Our Ref: FP223
Your Ref: SSD-9653

STATE SIGNIFICANT DEVELOPMENT APPLICATION – SHOWGROUND STATION PRECINCT

Thank you for the opportunity to provide feedback on the State Significant Development Application (SSDA) for the Hills Showground Precinct (Government Land). The following comments are provided on behalf of Council:

Height plan

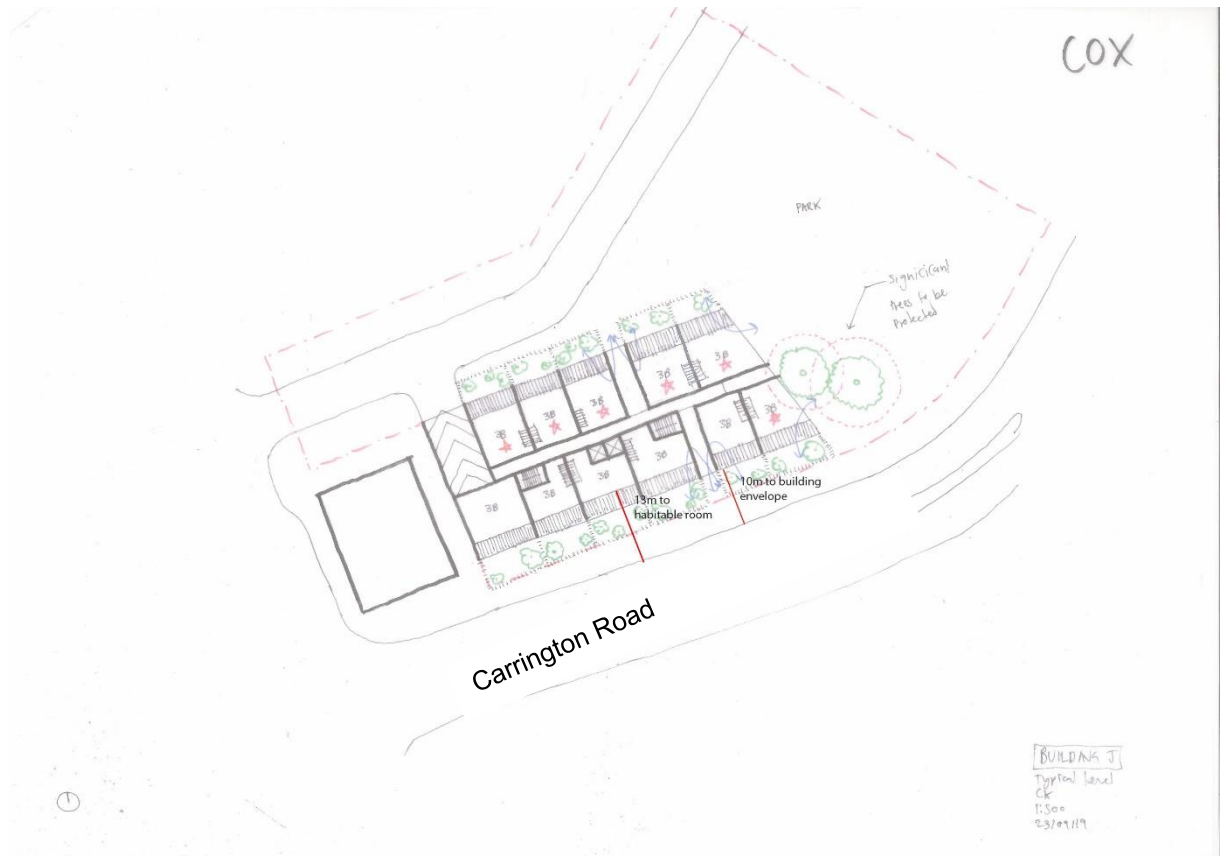
It is further noted there are inconsistencies between the proposed building heights within the Urban Design Report (page 91) which includes some two and three storey elements in the Doran Drive Precinct and the Plans for Approval (Drawing No. SK7) which identify buildings ranging from four storeys to 20 storeys. Consistency between all of the relevant information is considered paramount if these documents are to be used to guide future built form outcomes.
